DEVELOPMENT FACILITATION TEAM

DRB Project Number: 2022-006935
10900, 10901, 10915 Juan Tabo Pl.

SUBJECT: Sketch Plat

DRB Project Number: 2022-006935 Hearing Date: 06-21-2023
Project: Lot 1A – 14A, Juan Tabo Business Park Agenda Item No: 6

# SKETCH PLAT

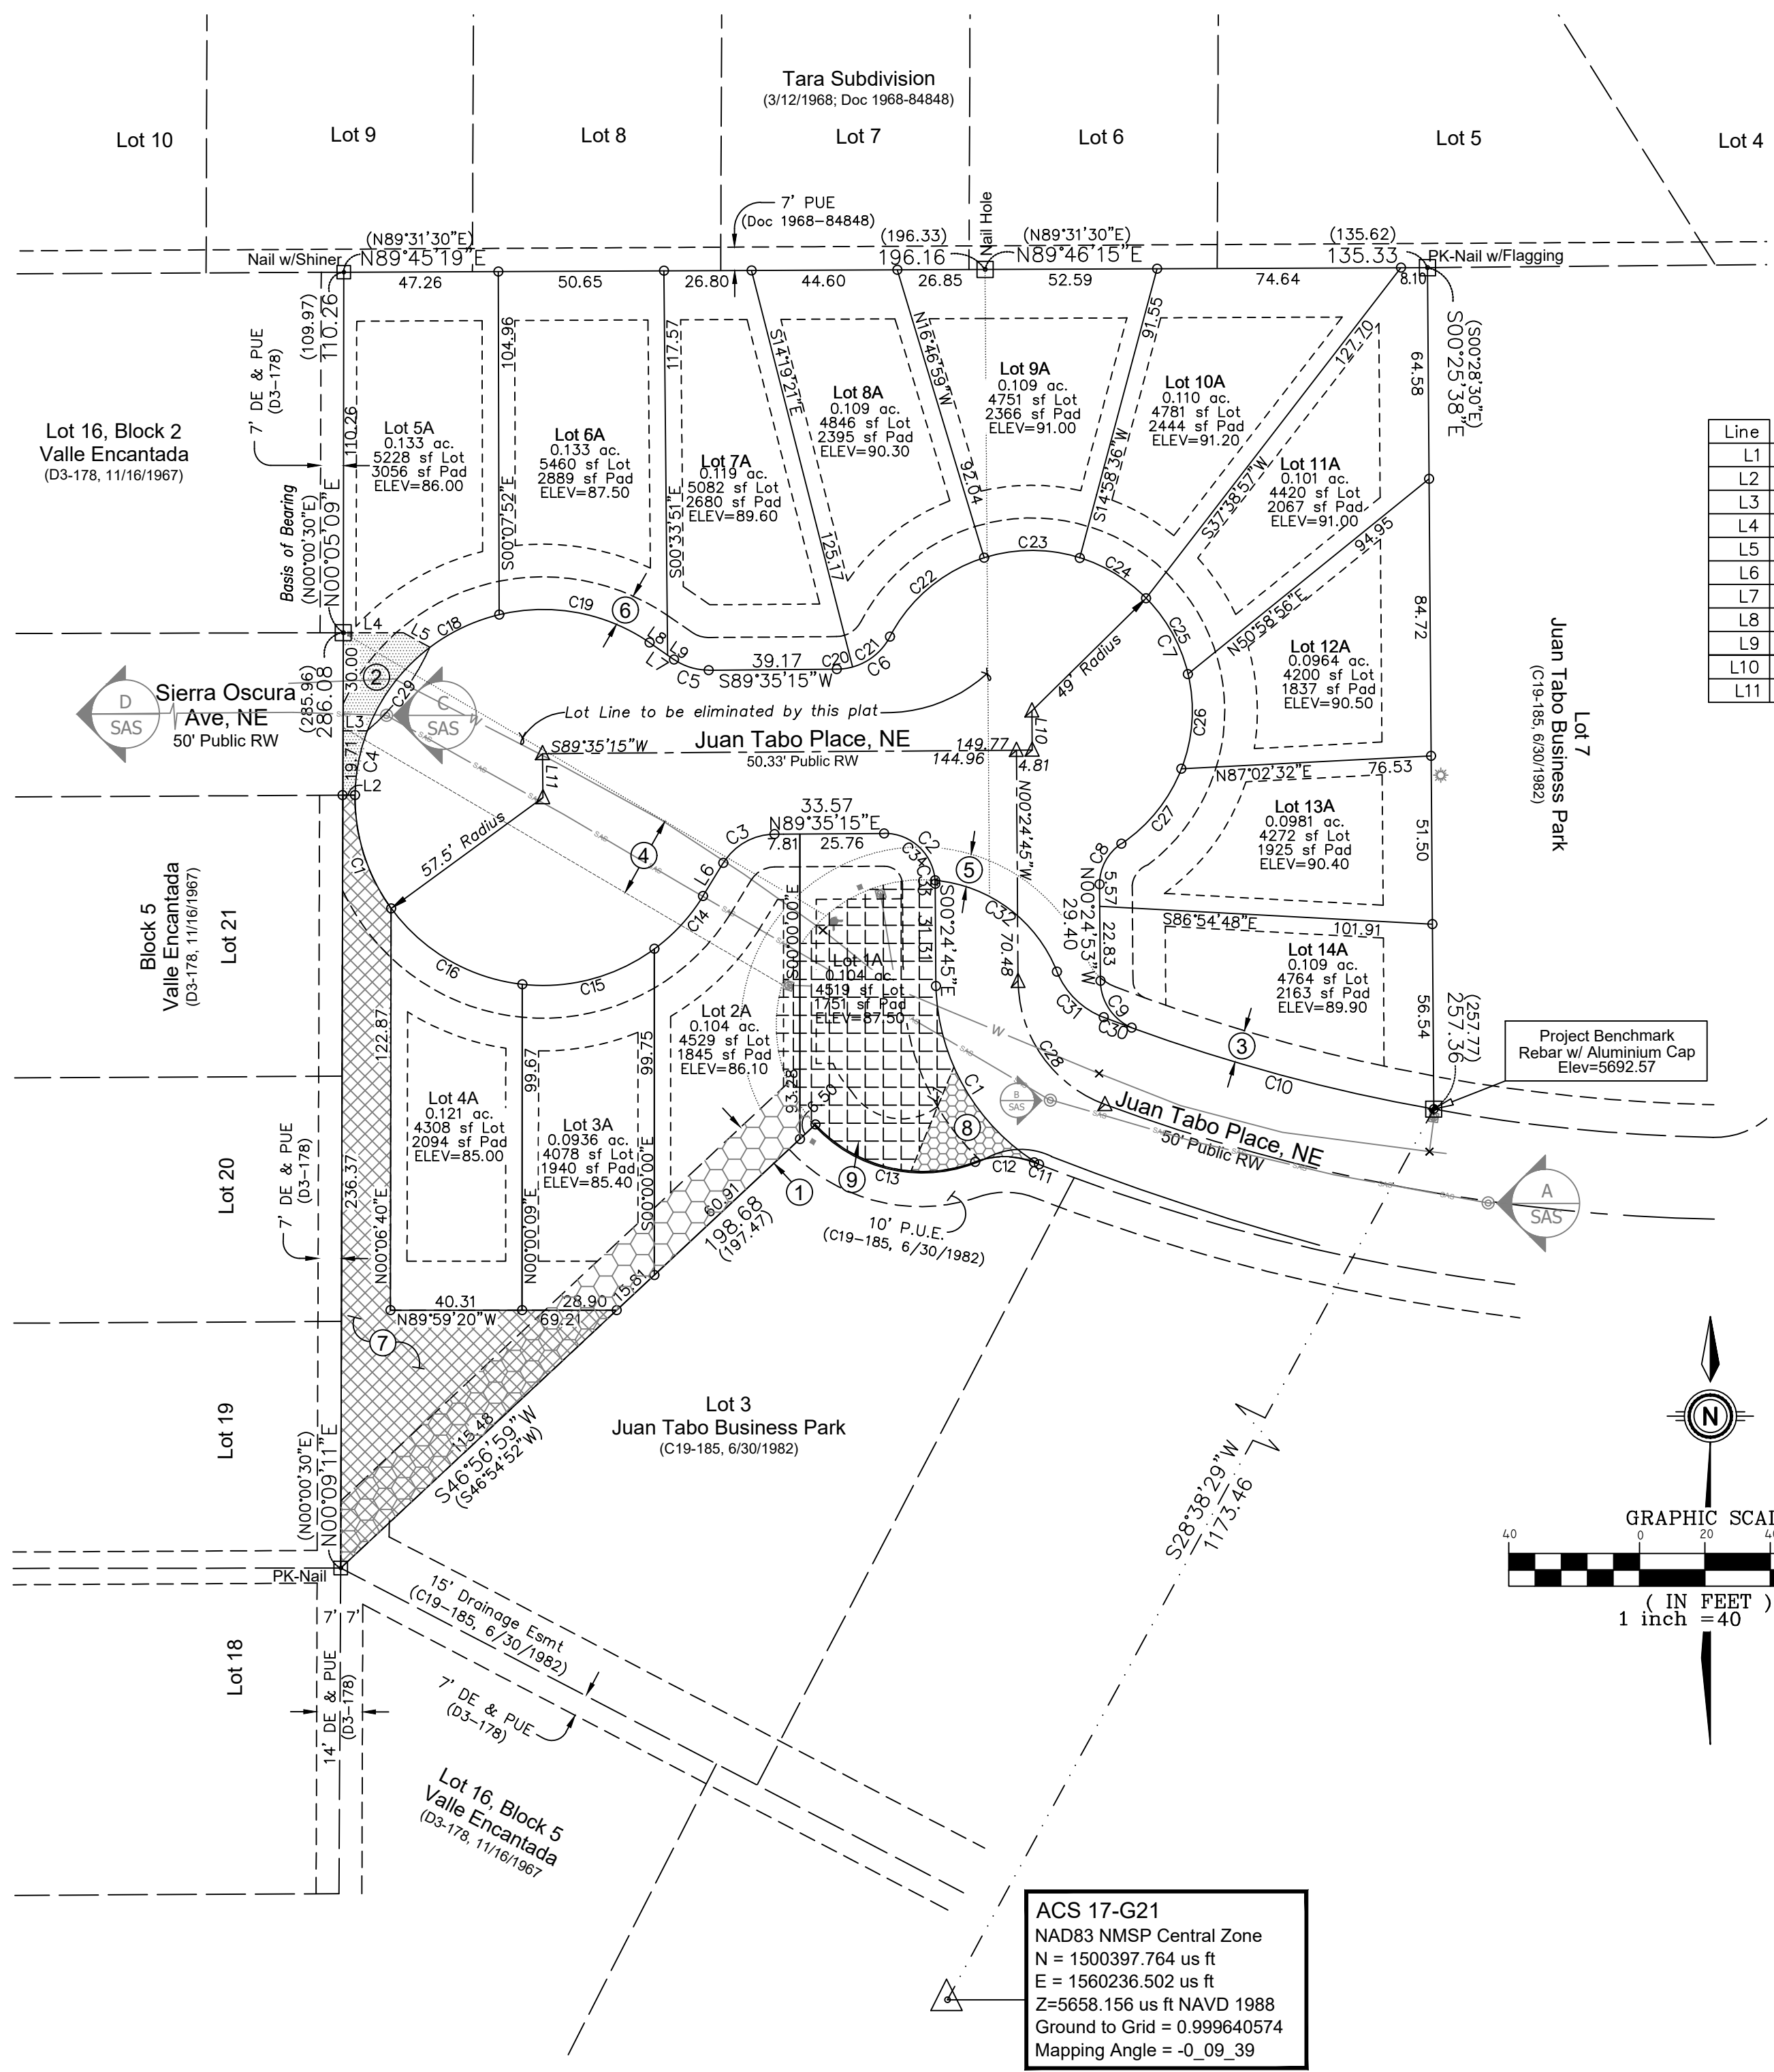
1. For both existing portions and proposed portions, Juan Tabo Pl. is considered a local street and requires 5' sidewalks and 4-6' landscape buffers. Show cross-sections to ensure it will be located within right-of-way, and dedicate any right-of-way as necessary. All infrastructure shall be placed onto an infrastructure list and be reviewed through the work order process.

1. Availability Statement 230106 has been executed and provides conditions for service for a subdivision that appears to be different than what is proposed in this lot configuration.

- a. Please send updated information to Utility Development so we can revise the statement accordingly.
 - b. As proposed, a relocation of the public water and public sanitary sewer appears to be appropriate for the proposed plat.

1. Properties are zoned MX-T, Mixed Use Transition zone, and must meet all Dimensional standards as per IDO section 5-1(D), Table 5-1-2. Single-Family Homes are a permissive use.
2. Regardless of size of lot, proposed development for low density residential use must meet requirements for a 20 foot driveway, as per IDO 5-3(C)(3)(b).
3. Code Enforcement has no further comments and no objections.

- ***Demonstrate compliance with section 7 of the DPM Table 7.2.29 regarding Sidewalk width requirements and its landscape buffer.**
Verification of standards per Transportation
Property is not within a Center or Corridor area.
Juan Tabo place is Local Street. A 5-foot wide sidewalk and a 4-6-foot wide landscape buffer is required.
